Contact: Kate MacDonald
Phone: 02 9228 6435
Fax: 02 9228 6540
Email: kate.macdonald@planning.nsw.gov.au
Our ref: MP10_0171 MOD 3

330 Church Street, Parramatta (MP10_0171 MOD 4)

Attachment 1

SHADOW DIAGRAM - EQUINOX (MARCH 21ST) 9.00AM
1:2000 @ A1

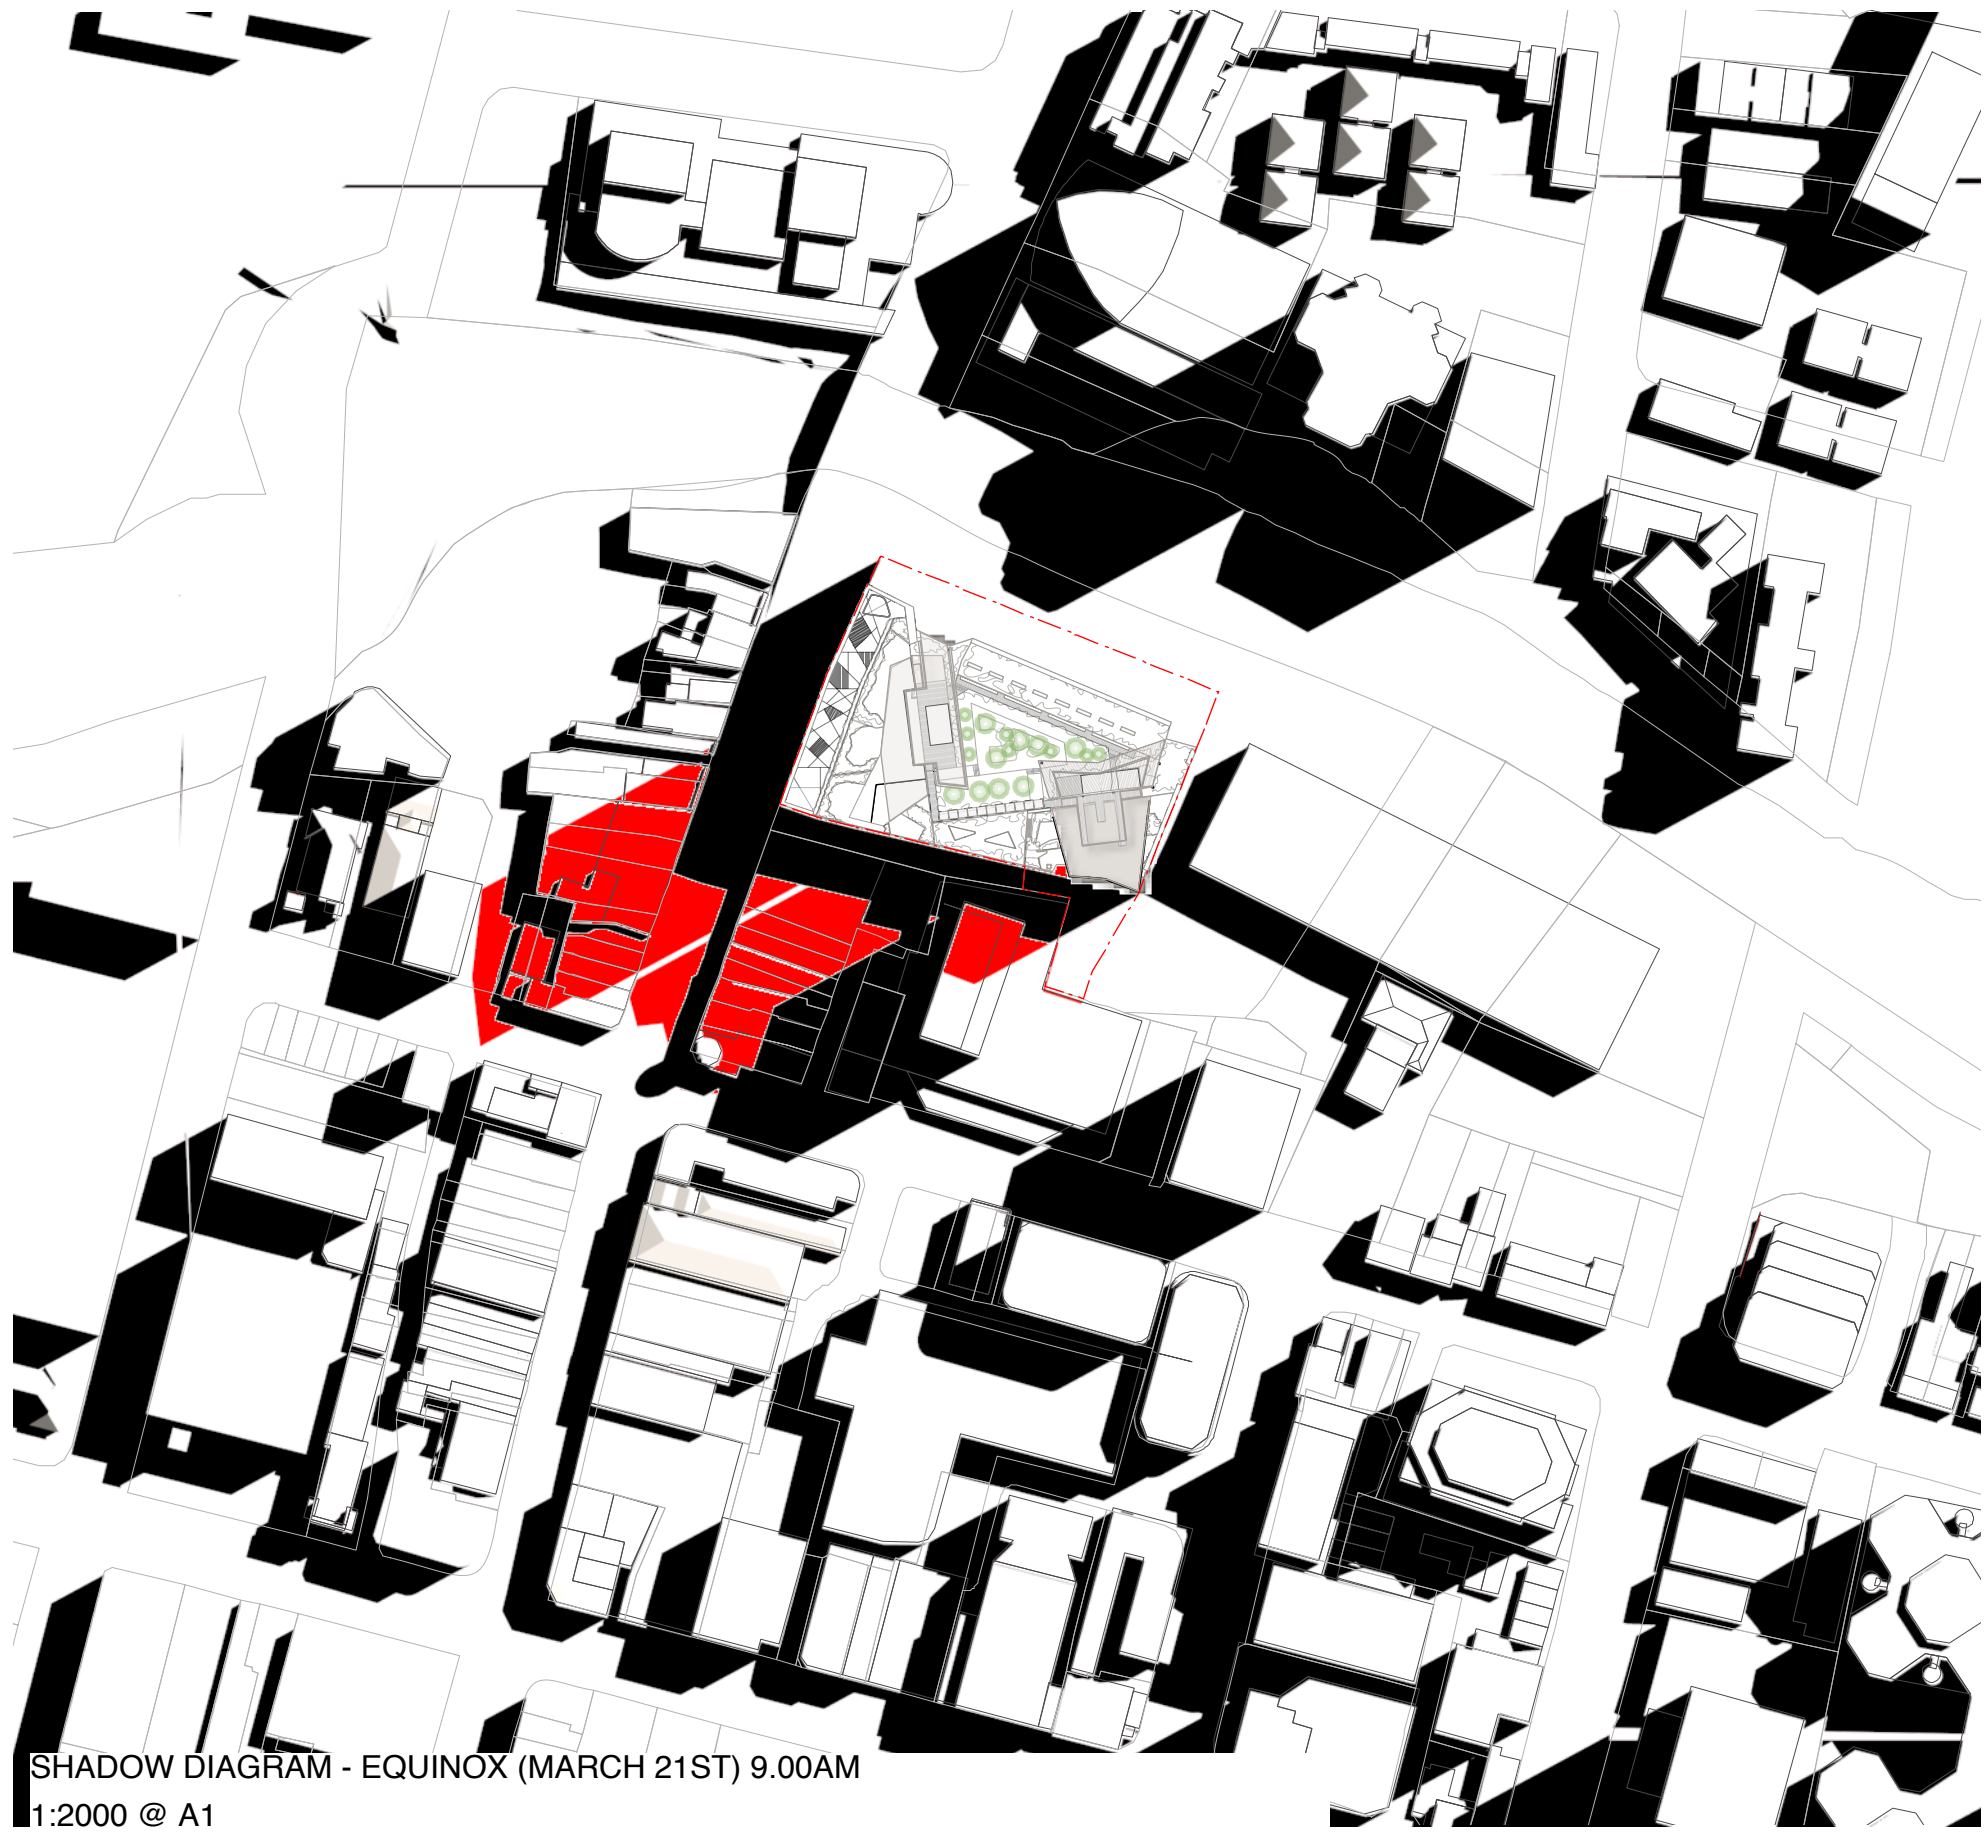
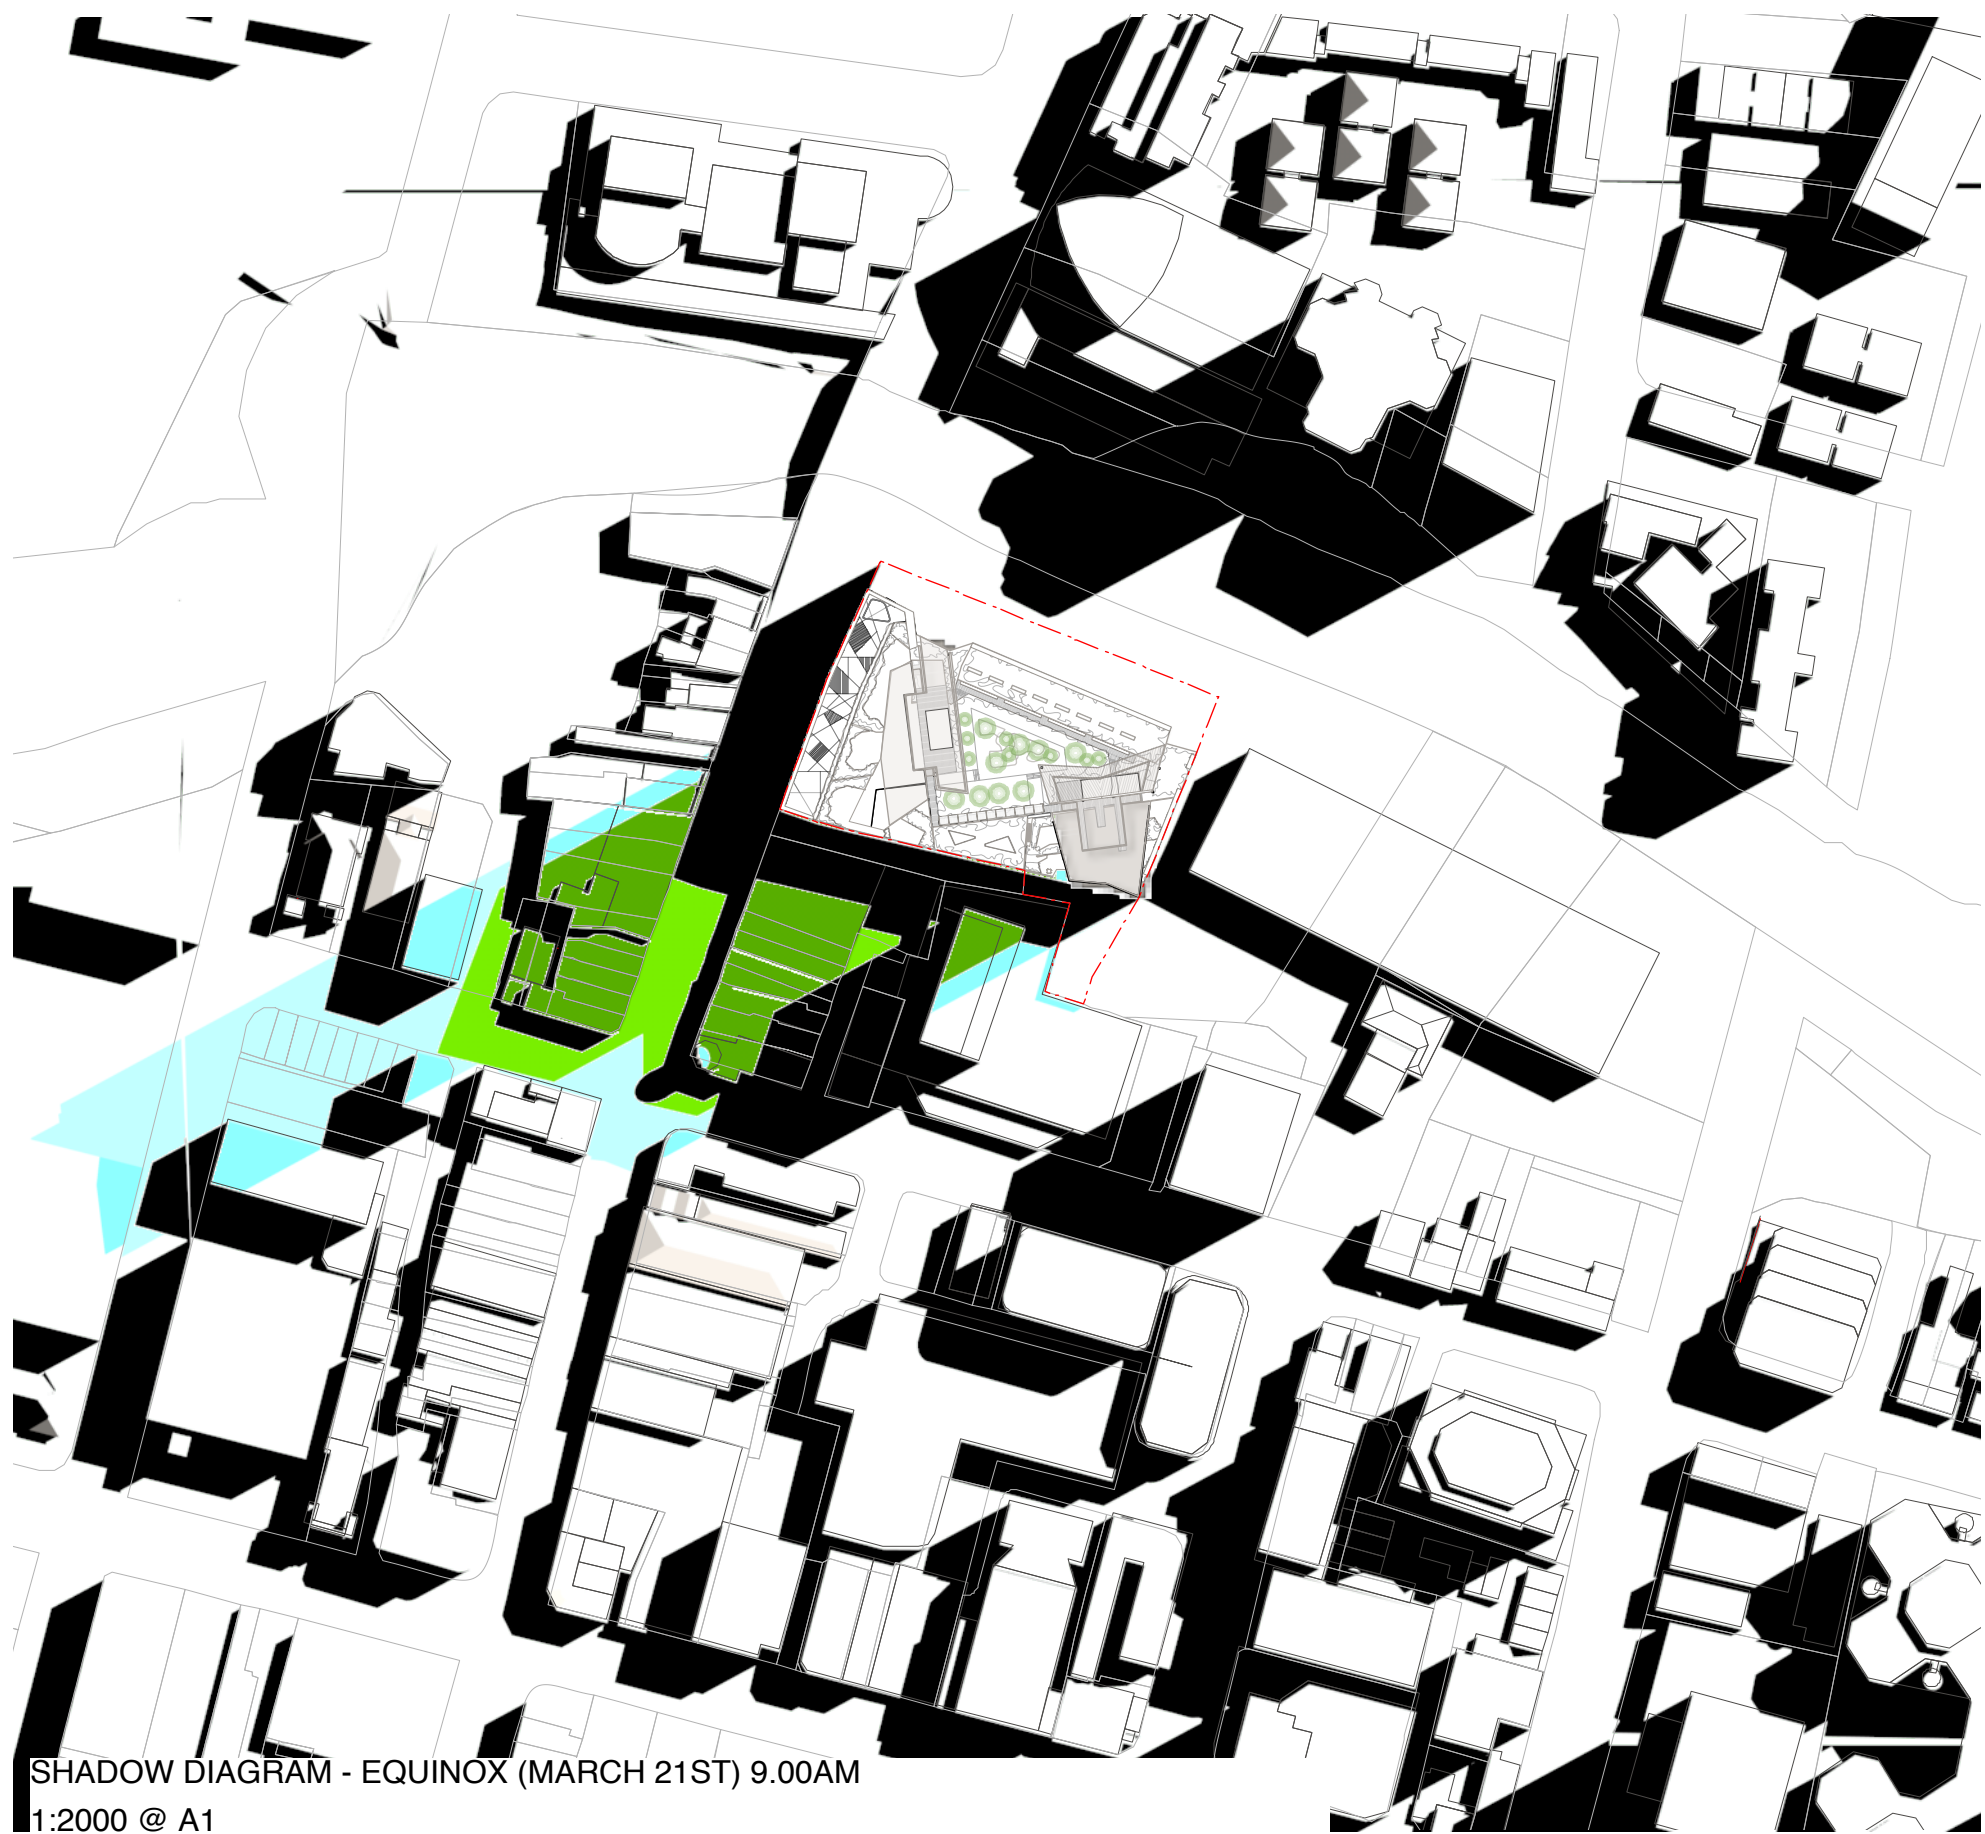
The shadow diagrams must be revised to reflect any revisions to the proposed building.

01 ELEVATION - WEST
1:200 @A1

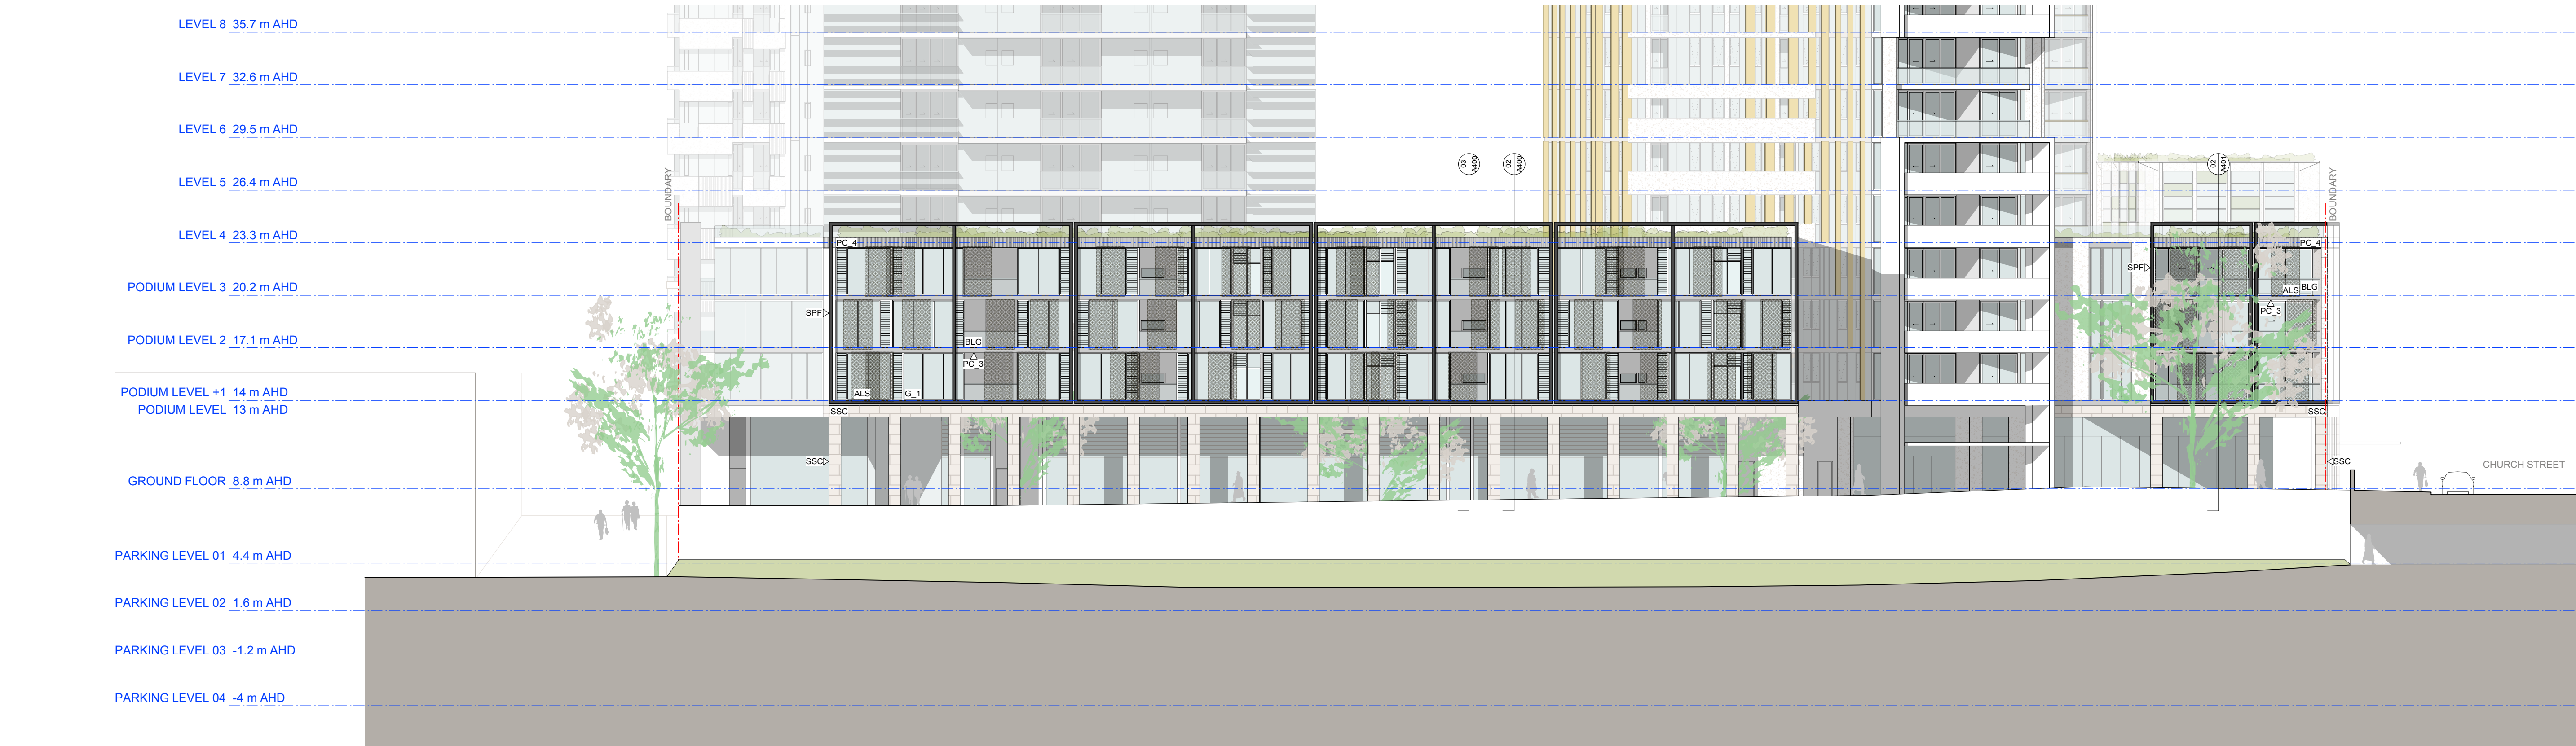
The department has reviewed the heights proposed for the eastern and western towers in the context of the likely future character of the Parramatta CBD. Based on this review the department considers that the proposed heights are not appropriately justified in terms of the transition between the centre and the periphery of the CBD. Furthermore, the department is concerned about the urban design impacts of the proposed modification on the profile of the northern edge of the CBD.

In addition, the department has also concluded that the proposed modification would create a significant height disparity between the eastern and western towers which would lead to a less harmonious built form outcome. In this regard, the final design of the building should maintain a similar height ratio between the two towers as identified under the current project approval (a height ratio of approximately 1.5:1 between the western and the eastern tower).
